Application number: 2025/92713	
What is the application for?:	Reserved matters application pursuant to outline permission 2023/92079 for erect
Address of the site or building:	Rear of, 23 to 43, Moor Lane, Gomersal, Cleckheaton, BD19 4LF
Postcode:	LS10 1NB

Type of comment: An objection	
Do you wish your comments to be published on the website anonymously?	Yes
Re Revised Plans dated 24th June 2026 Planning Moor Lane Issues After many deliberations, objections and comments, the latest KC Strategic Planning Committee meeting was held on the 11th June 2026. Issues relating to House Type / sizes, Bin travel distances, proximity of plot 10 to Summerdale and the poor access off Moor Lane were discussed by the councillors and members of the public. Subsequently revised plans were submitted by PPJ Developments and in my opinion they appear to satisfy most of the concerns. However the revised plans have not addressed Plot 1 which is still shown as a 3 storey house, and another 3 storey house is now planned for Plot 5. Whilst plot 5 maintains the eaves level at the top of the 1st floor windows (as are all the other houses), this has the 2nd floor within the roof space, with typical sloping c

PROPOSED SITE EXTRACT 1:100 @ A1

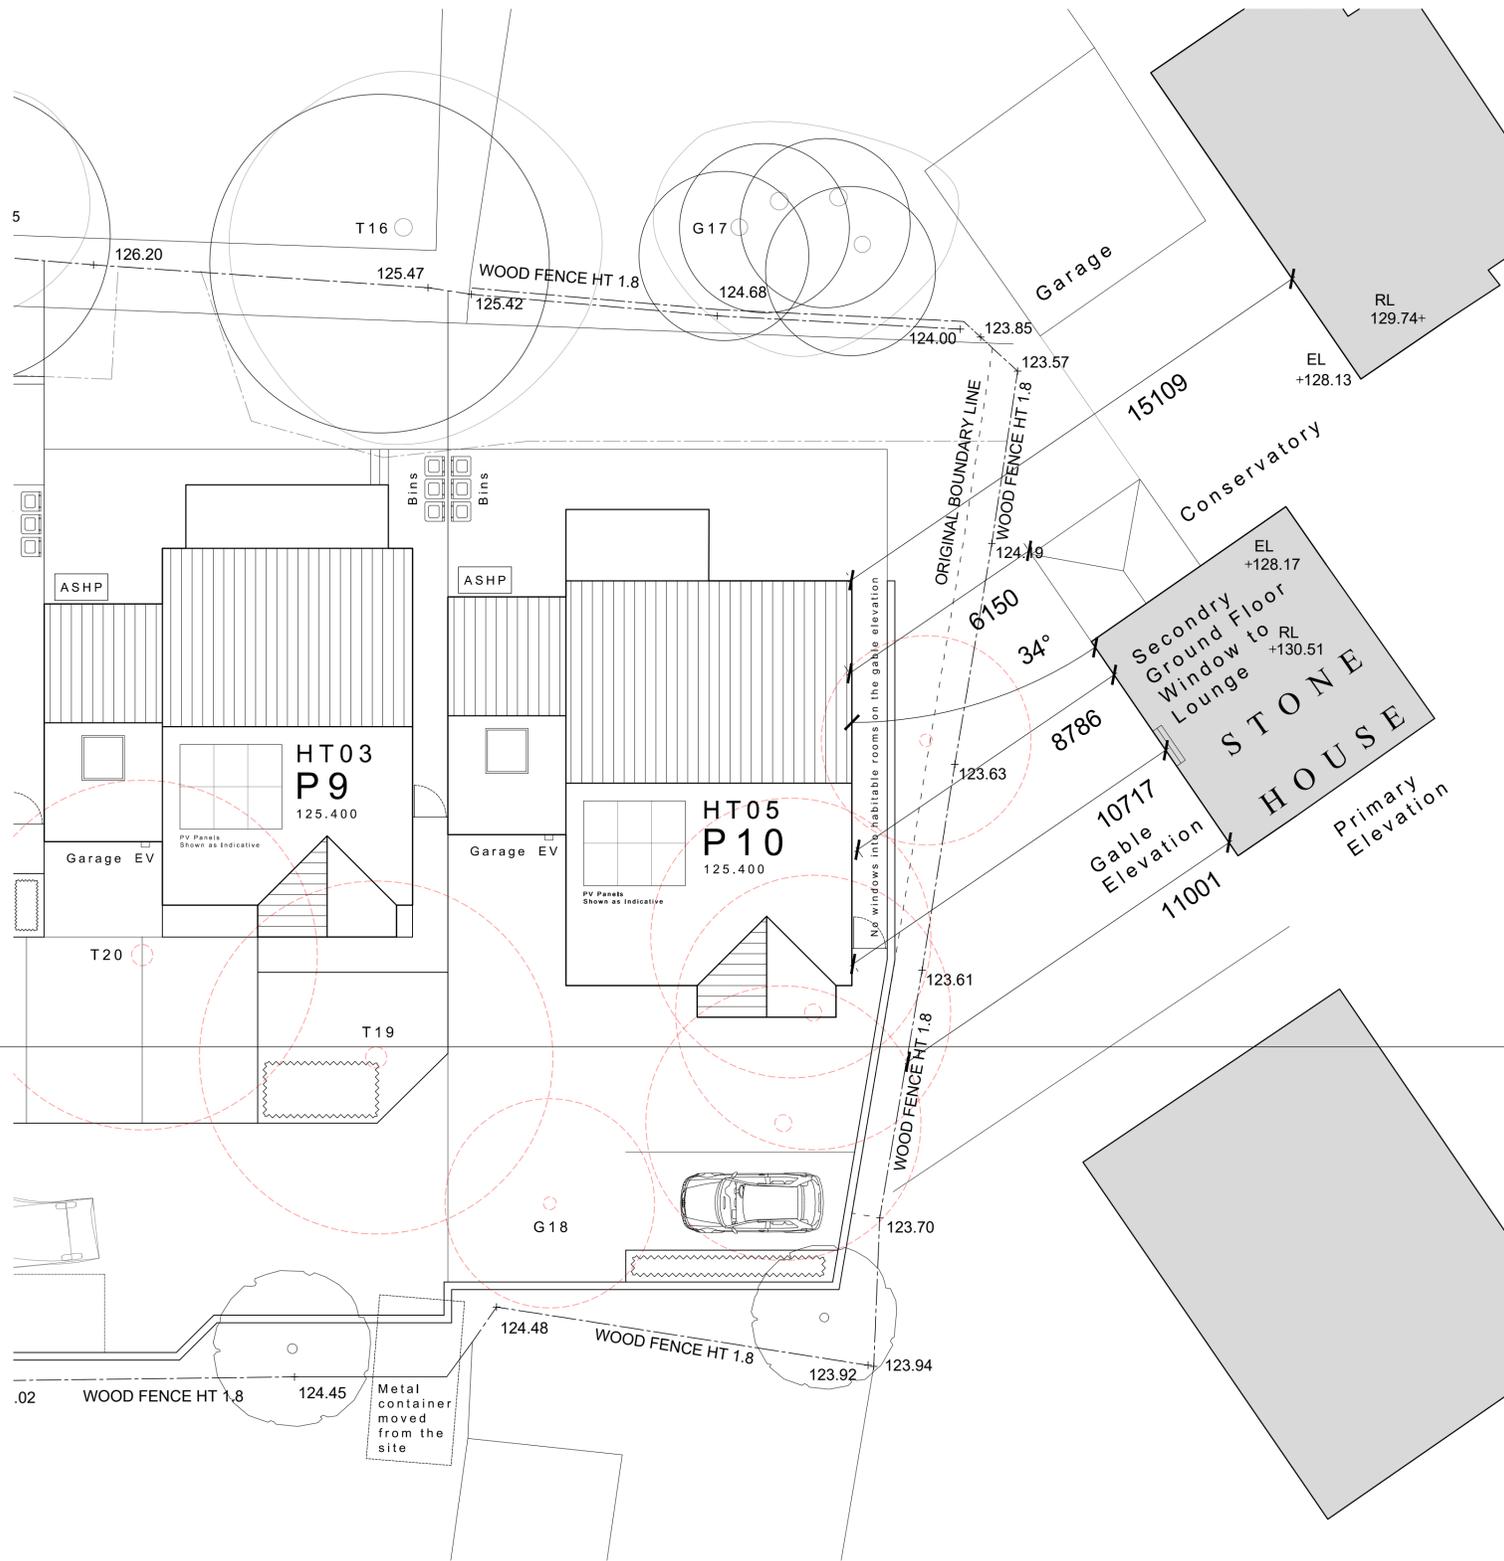
Furthermore, the actual kerbs have still to be finished in the vicinity of the boundary between No 27 and 29 Moor Lane. It appears to me that to achieve the “ Approved sight line” distance this will need to extend into the private garden of No 29. This house has a hedge and stone wall terminating at the road edge.

Without knocking part of the wall down and removing the hedge and shrubs the “ Approved sight line” criteria will not be met.
